O'Connell Street Public School (MOD 5) (SSD 7372 Mod 5)  
**Request for Additional Information**

I refer to the Structural Drawing plans provided with the Response to Submissions for the O'Connell Street Public School (MOD 5) (SSD 7372 Mod 5). After careful consideration, the Department is requesting that you provide additional information.

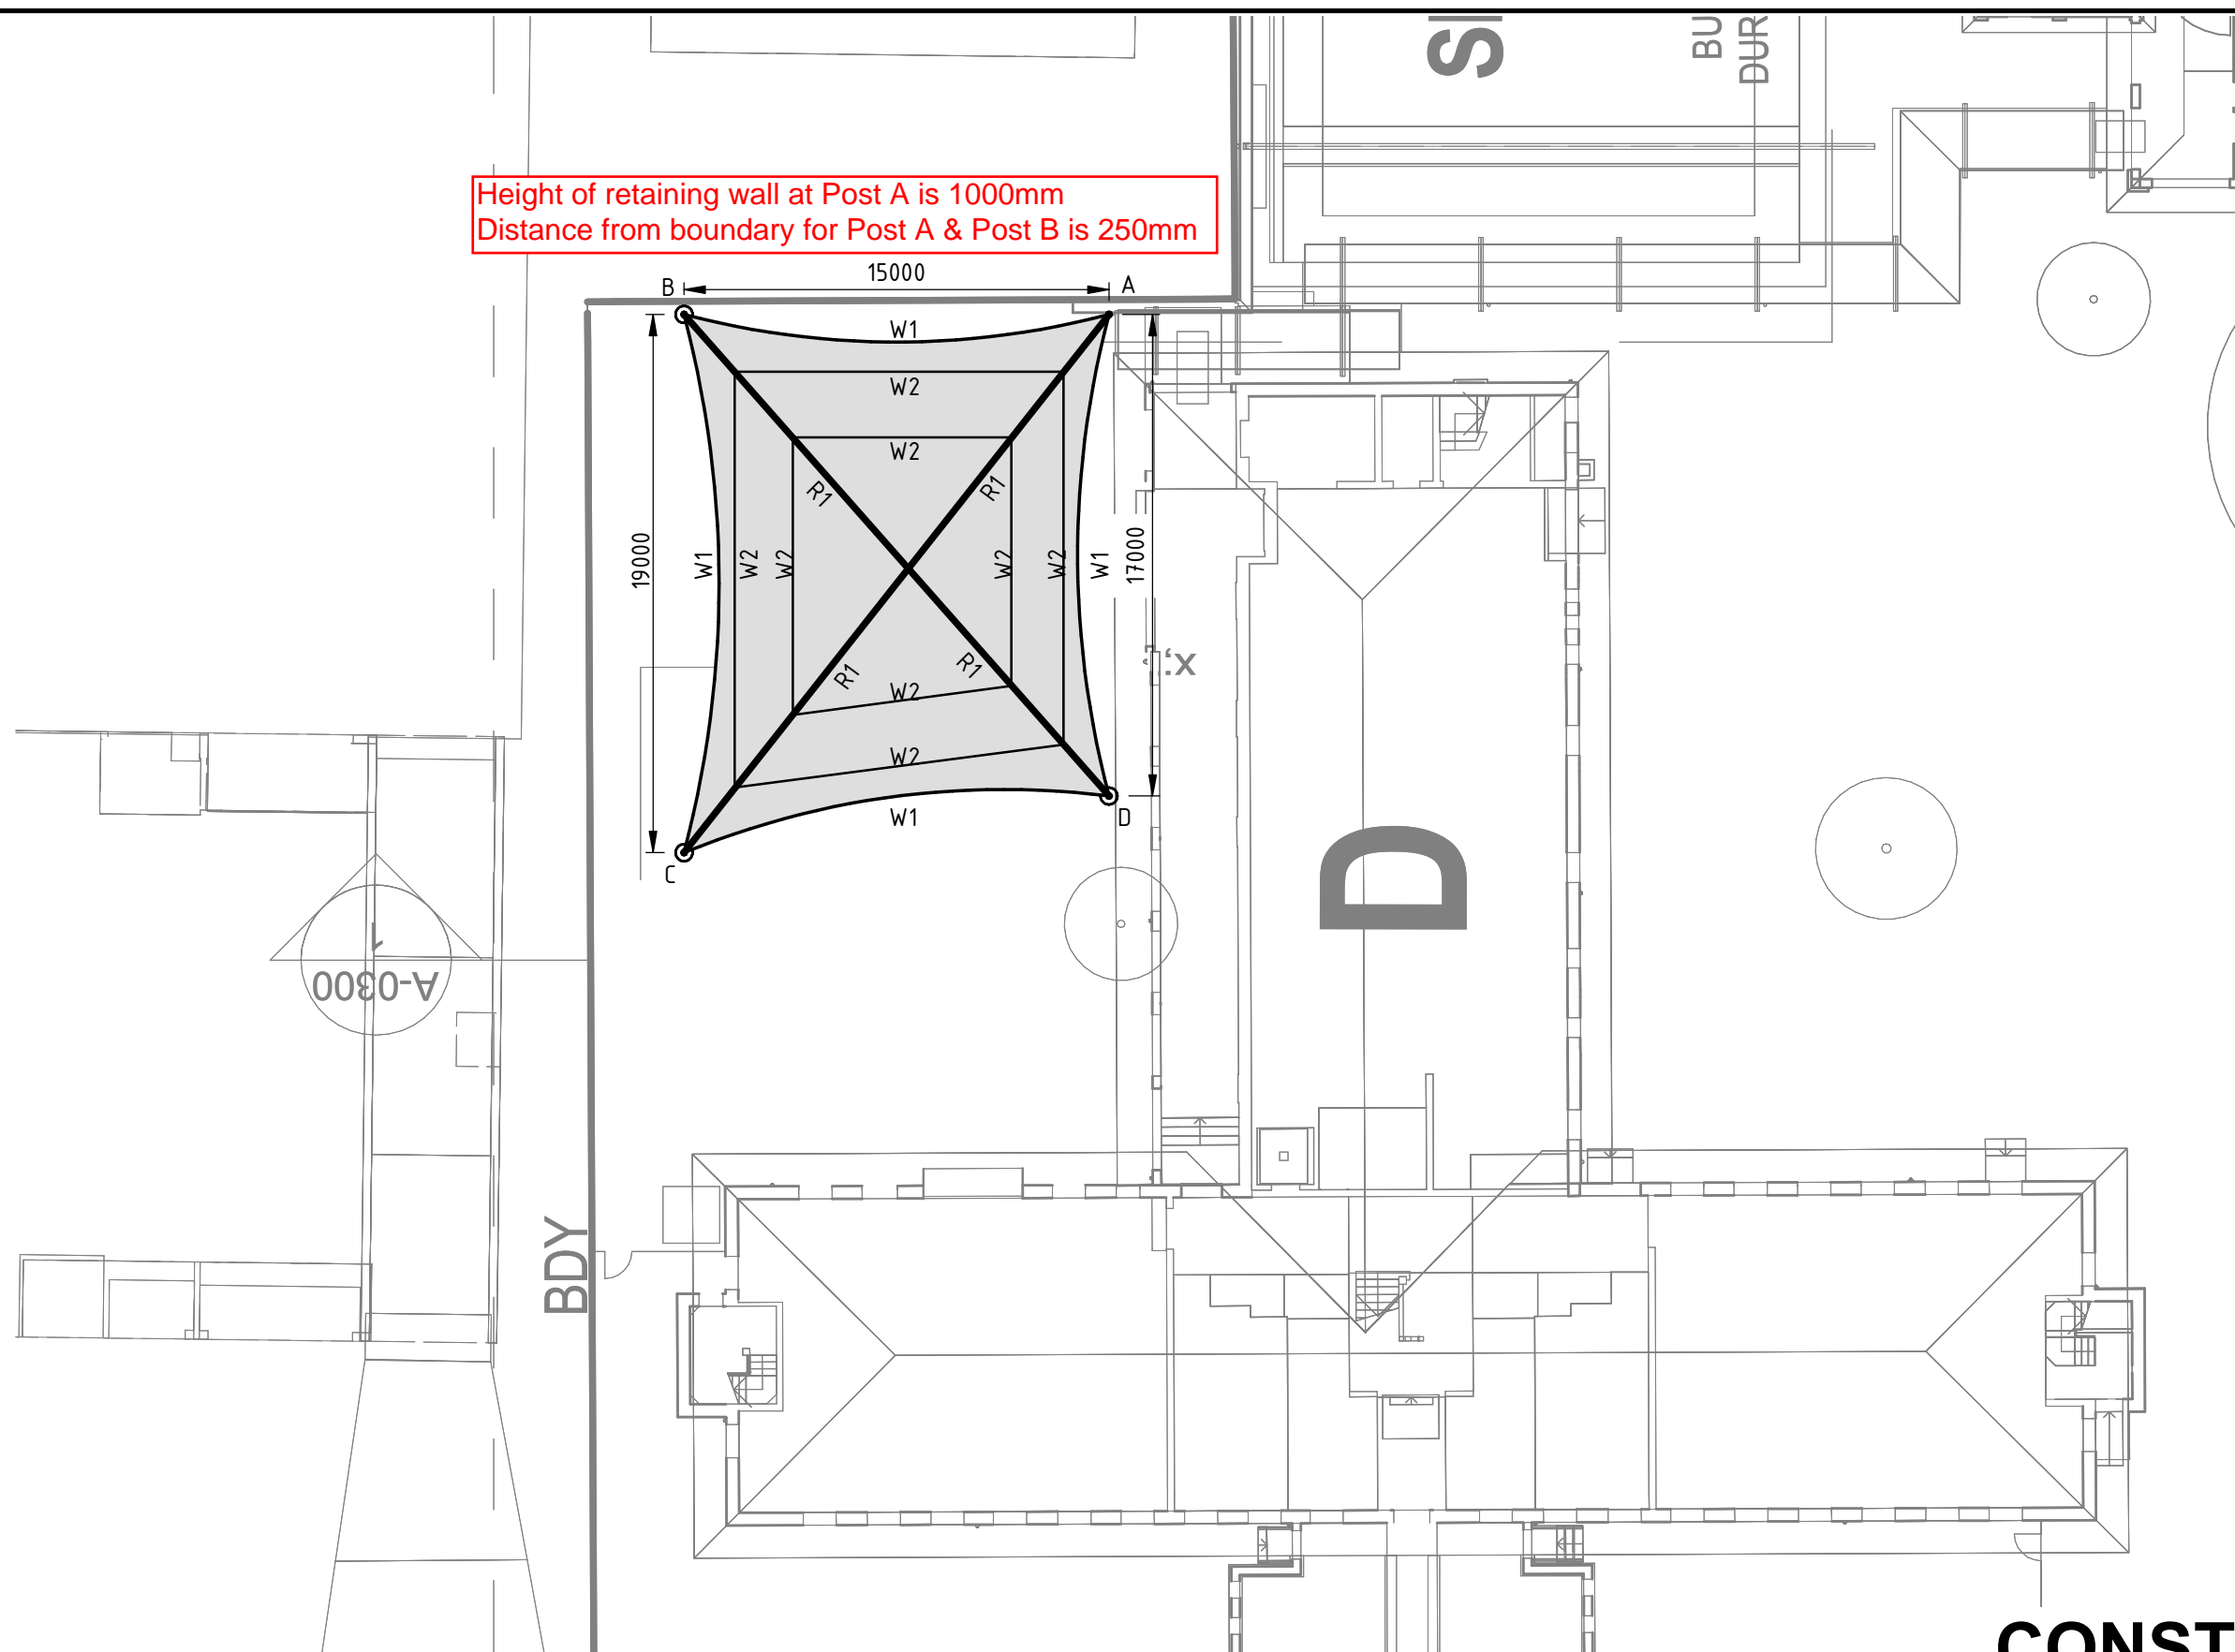
The Structural Drawing Location Plan (S05 Rev C) identifies that the revised shade sail is in line with the eastern façade of Building D and addresses the Heritage Division's comments on the initial design. However, Section A S02 of the Structural Drawing Framing Elevation (S03 Rev D) shows the A and B footings as 2m past the eastern façade of Building D which is inconsistent with the location plan (S05 Rev C) and the request of the Heritage Division.

Please provide revised plans that provide a consistent design of the shade sail in relation to the school building across both the elevation and the location plans.
